CITY OF PORTLAND

**City of Portland, Maine - Building or Use Permit Application**

Permit No: 06-1144	Issue Date: AUG - 9 2006	CBL: 055 B031001
-----------------------	-----------------------------	---------------------

Past Use: 2 Unit	Proposed Use: 2 Unit - INTERIOR DEMOLITION ONLY- connected w/ permit#061061	Permit Fee:	Cost of Work: \$0.00	CEO District: 2
Proposed Project Description: INTERIOR DEMOLITION ONLY- connected w/ permit#061061		FIRE DEPT: <input type="checkbox"/> Approved <input type="checkbox"/> Denied	INSPECTION: Use Group: <i>N/A</i> Type: <i>8/3/06</i> <i>[Signature]</i>	
		Signature:	Signature: <i>[Signature]</i>	
PEDESTRIAN ACTIVITIES DISTRICT (P.A.D.)				
Action: <input type="checkbox"/> Approved <input type="checkbox"/> Approved w/Conditions <input type="checkbox"/> Denied				
		Signature:	Date:

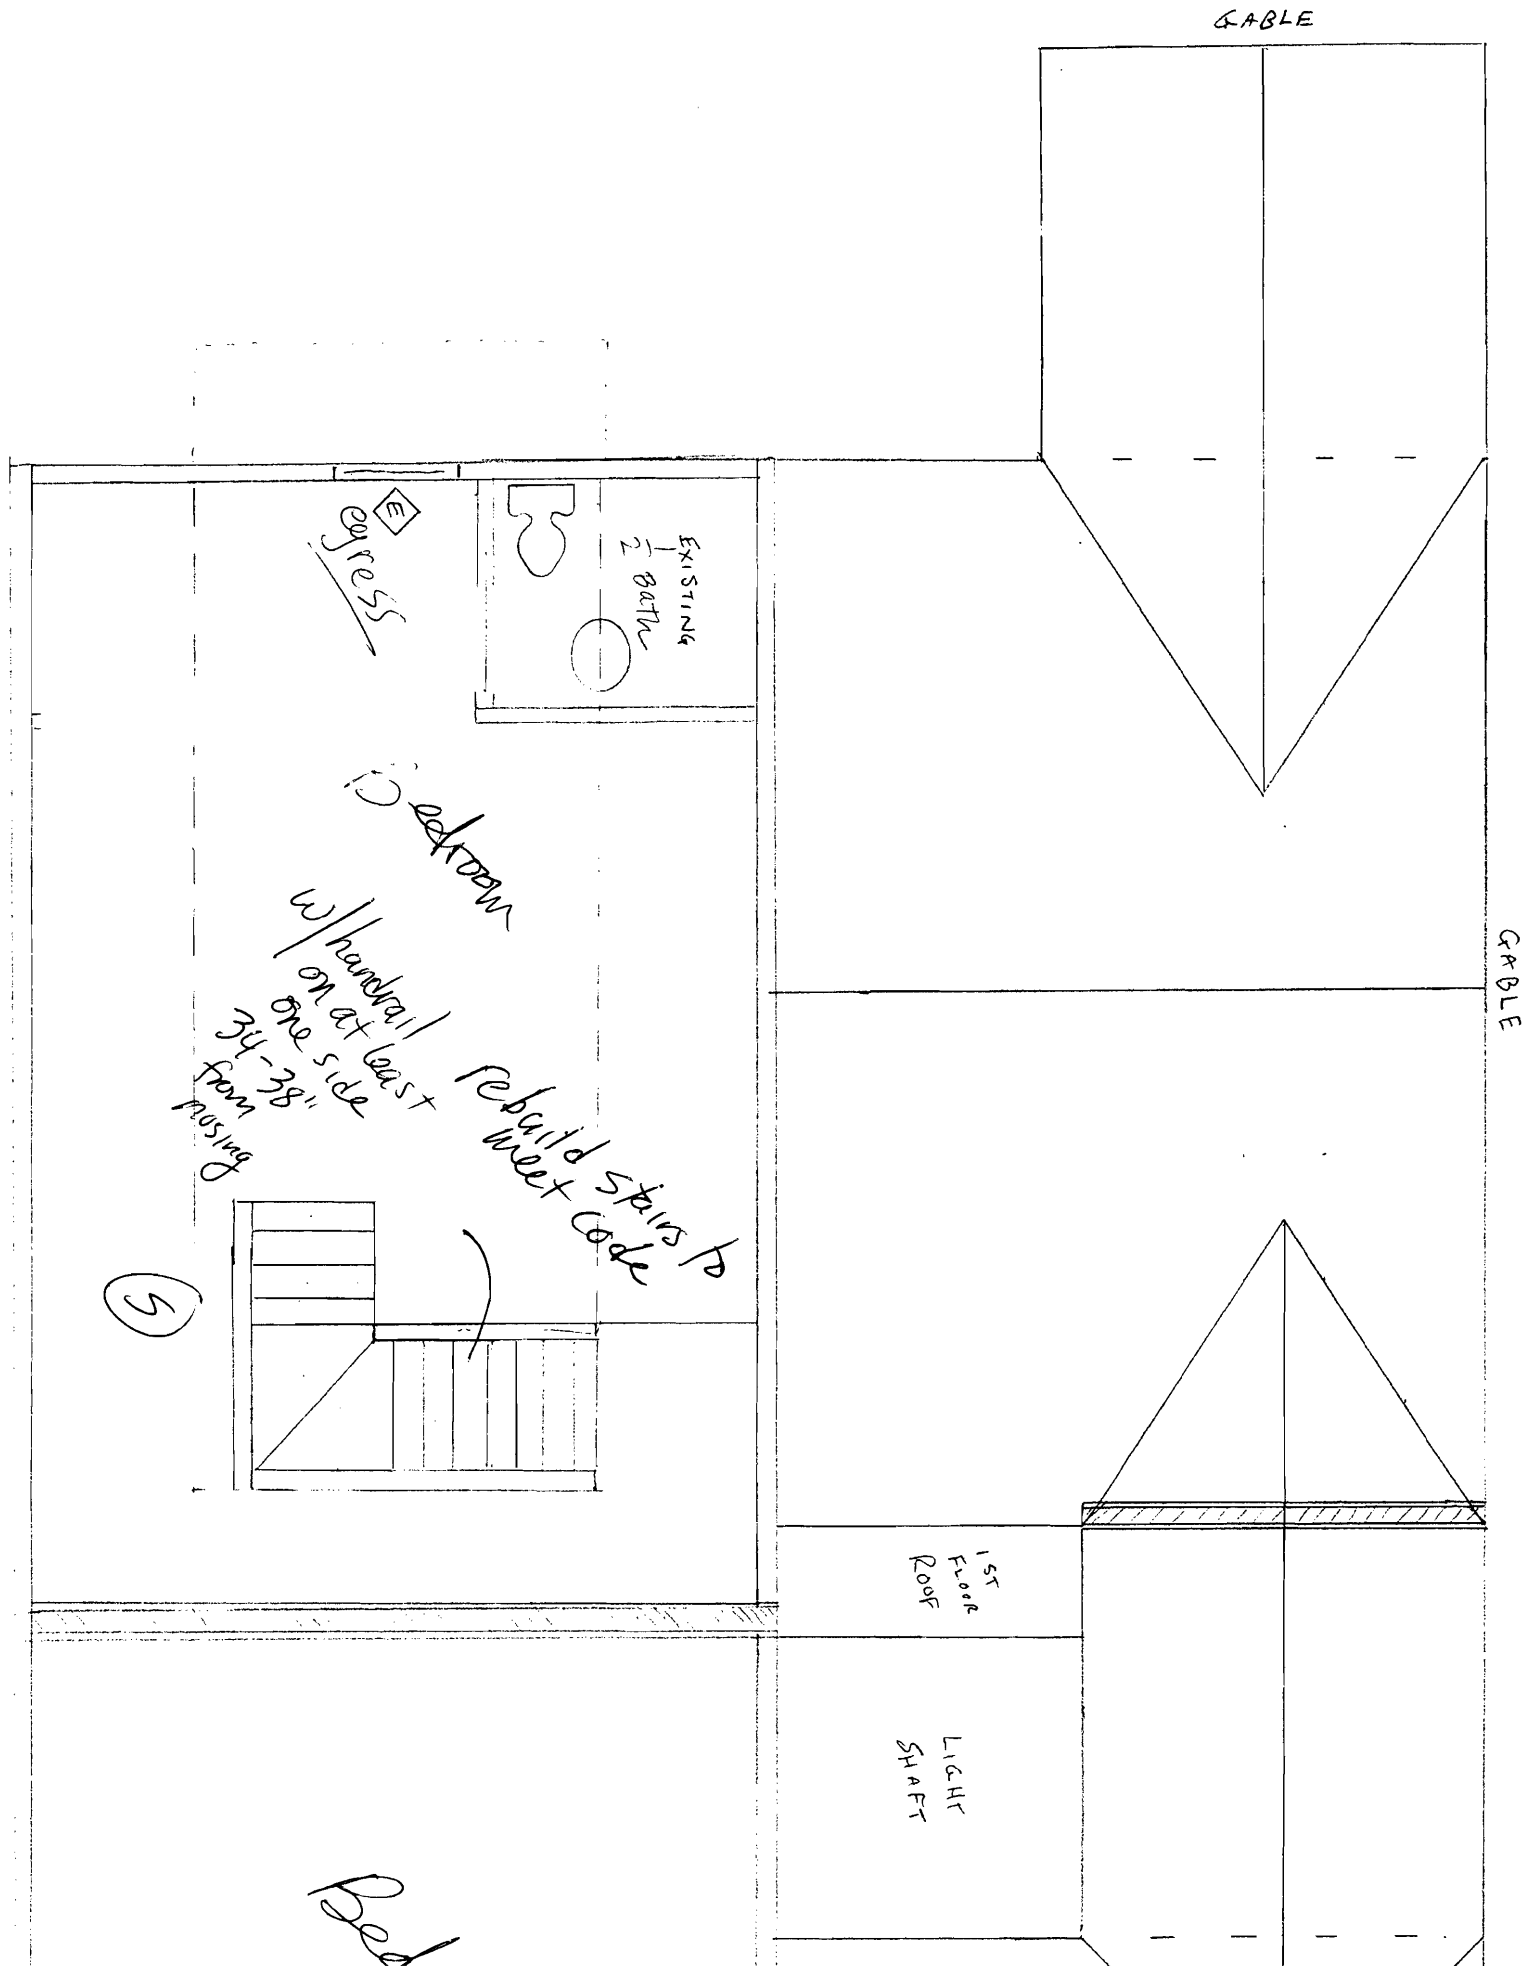
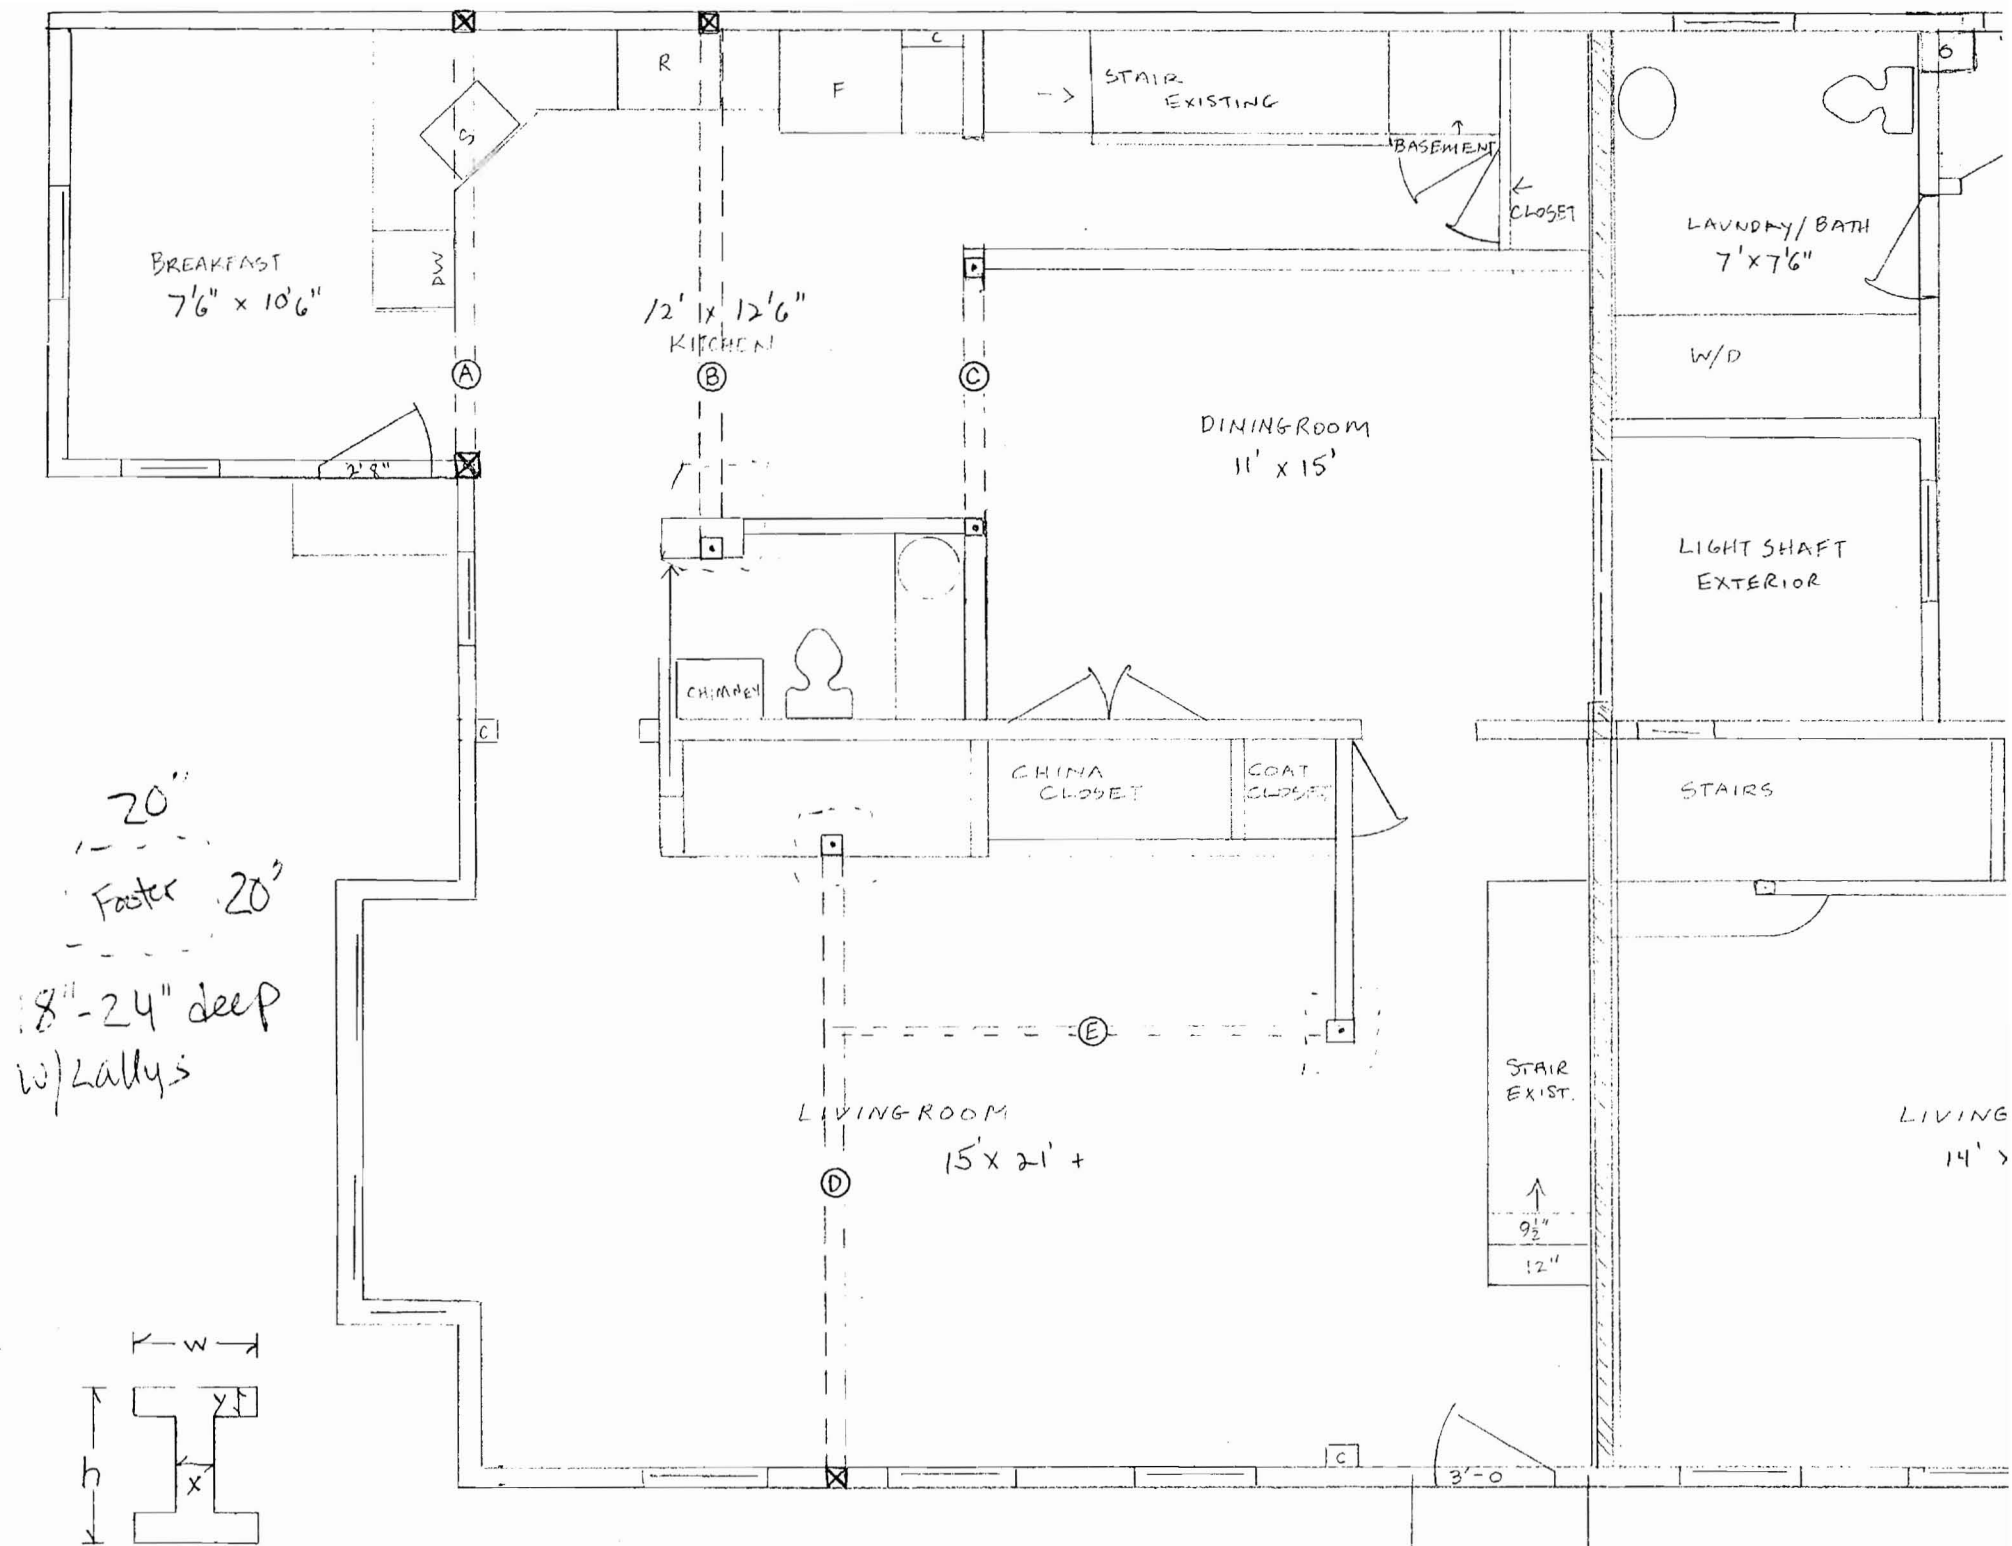
Massey Chimney -  
Joint support.

Headers above windows

AKay @ Tub/<sup>Shower</sup> corners all

STAIRS - Sheetrock -

3/30/07 - checked framing, went over issues  
from 3/19/07 all ok plumbing test ok &  
ok. checked electric ok. OK to Close-  
in.  
JMK
